R/141/15/PL

Re 8 Flint House,

I wish to protest about The
Planning Application for
The above property.

Drawing No:	15/05/2015	Date:	15th MAY 2015
Description:	BALCONY BALUSTRADE	Finish:	GALVANISED, PPC.
Project:	MR MARTIN

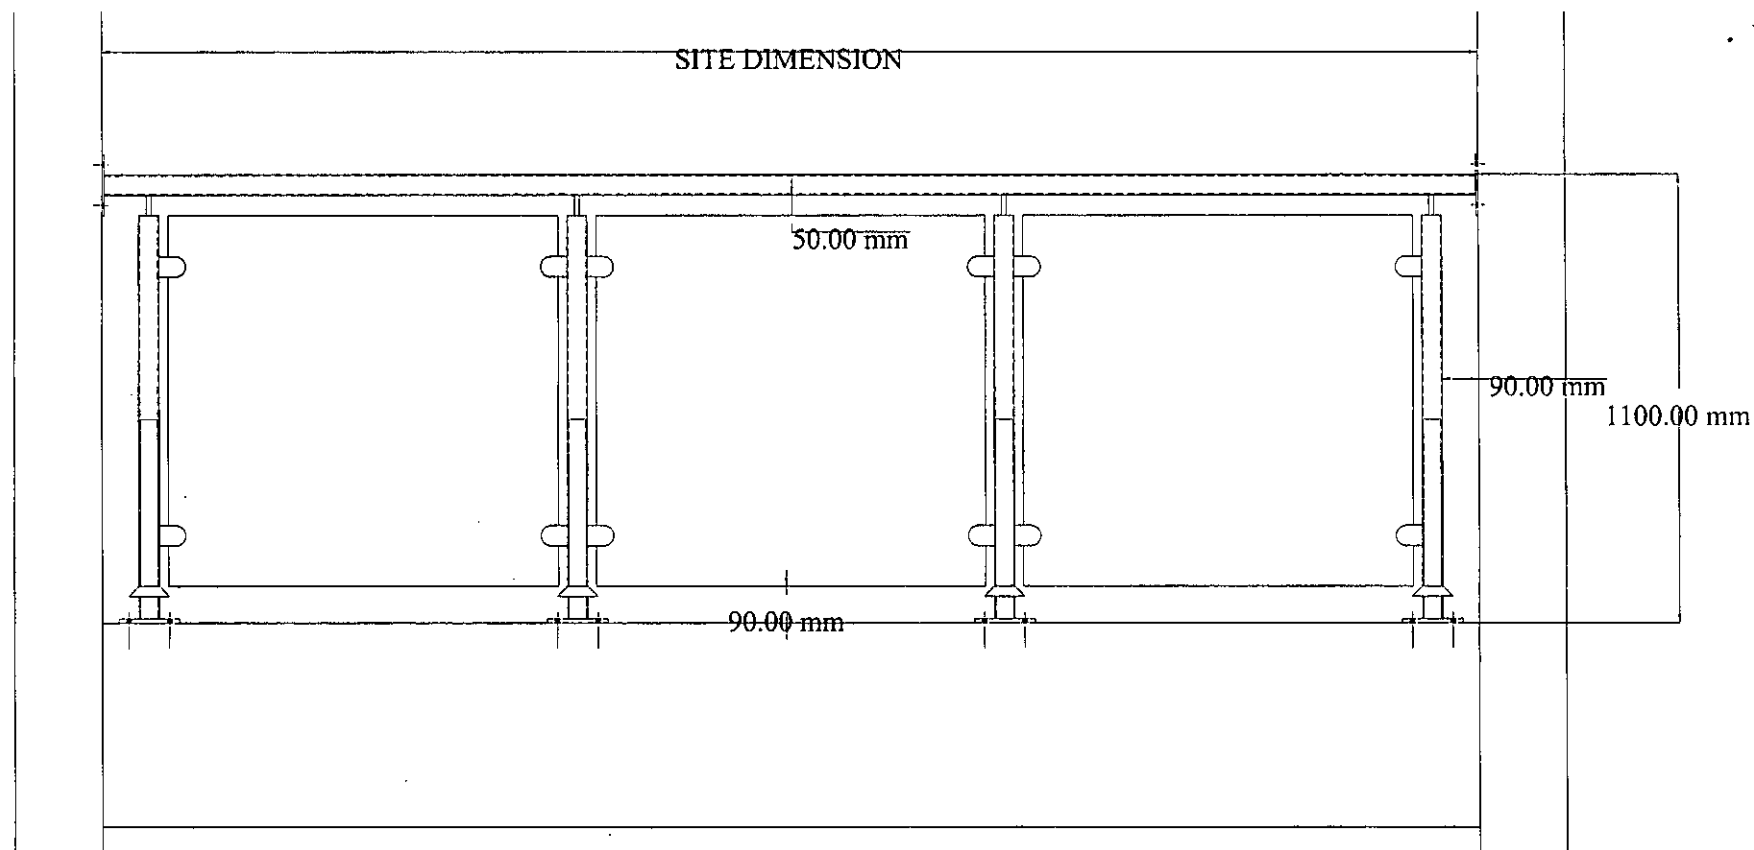
Whilst appreciating that
new railings are necessary
something more in keeping
with the overall look of
The Cudlow Garden complex
might be appropriate.

Railings like those on
Noddseter Lodge only in
white might be more
fitting.
